Planning application no.: 03.24.945

Location: Woodfield Ribchester Road, Langho BB6 8AL

Proposal: Proposed demolition of existing bungalow and garage and erection of a 2 storey dwelling house

Tahira Akhtar BA (Hons)
Technician
Highway Development Control
Highways & Transport
Lancashire County Council

Figure 1 – Proposed site plan

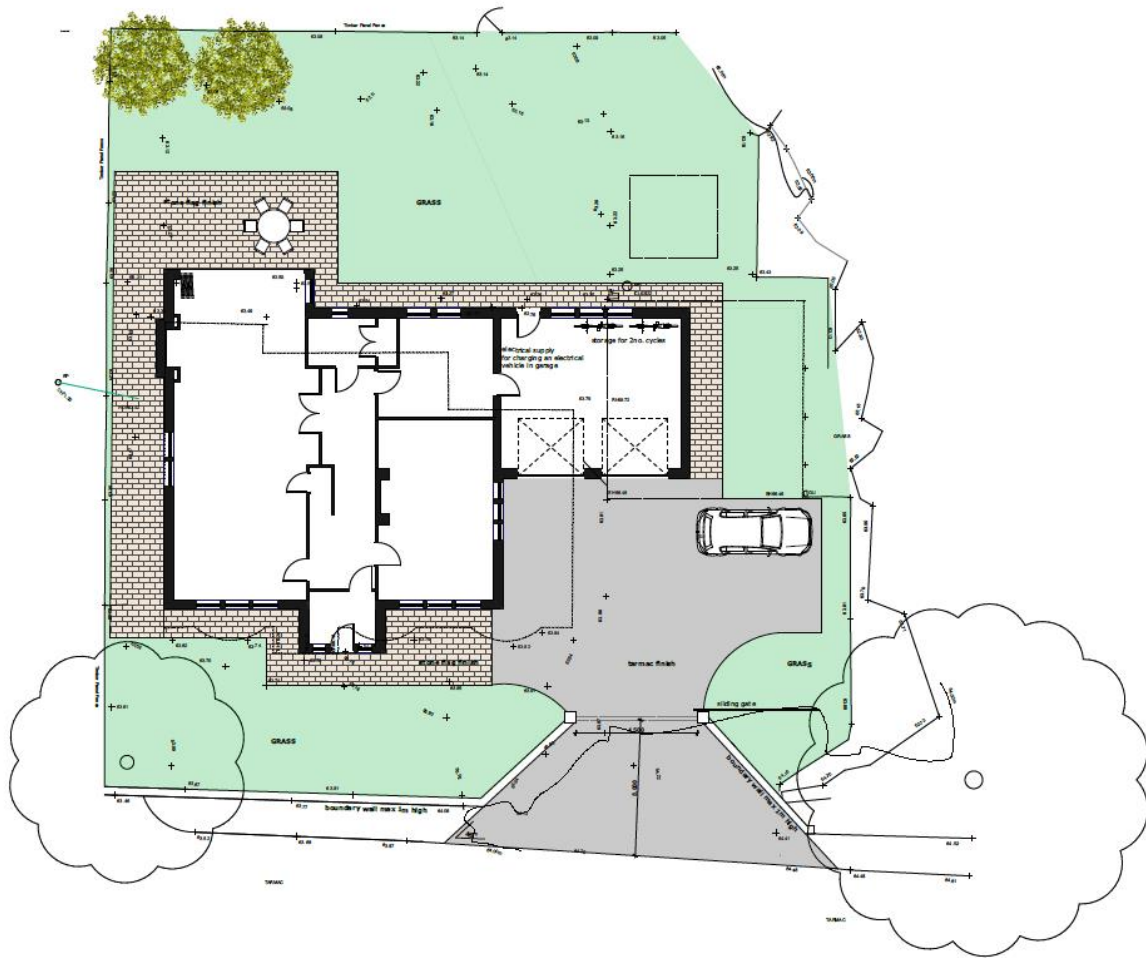
The proposal is to demolish the existing bungalow and garage and to replace with a two storey property with four bedrooms. With Ref.: Proposed site plan, drawing no. 16.123.003B submitted, in principle there is no objections to the proposed development subject to the following conditions

1. Prior to first occupation the site access, parking and turning area shall be laid out and paved in accordance with the approved plan and maintained thereafter for that use. Reason: To ensure adequate access, parking and turning provision.

2. The boundary walls along Ribchester Road shall be provided at a height not greater than 1m above the crown level of the carriageway of Ribchester Road. Reason: To ensure adequate visibility for the drivers of vehicles entering and leaving the site.
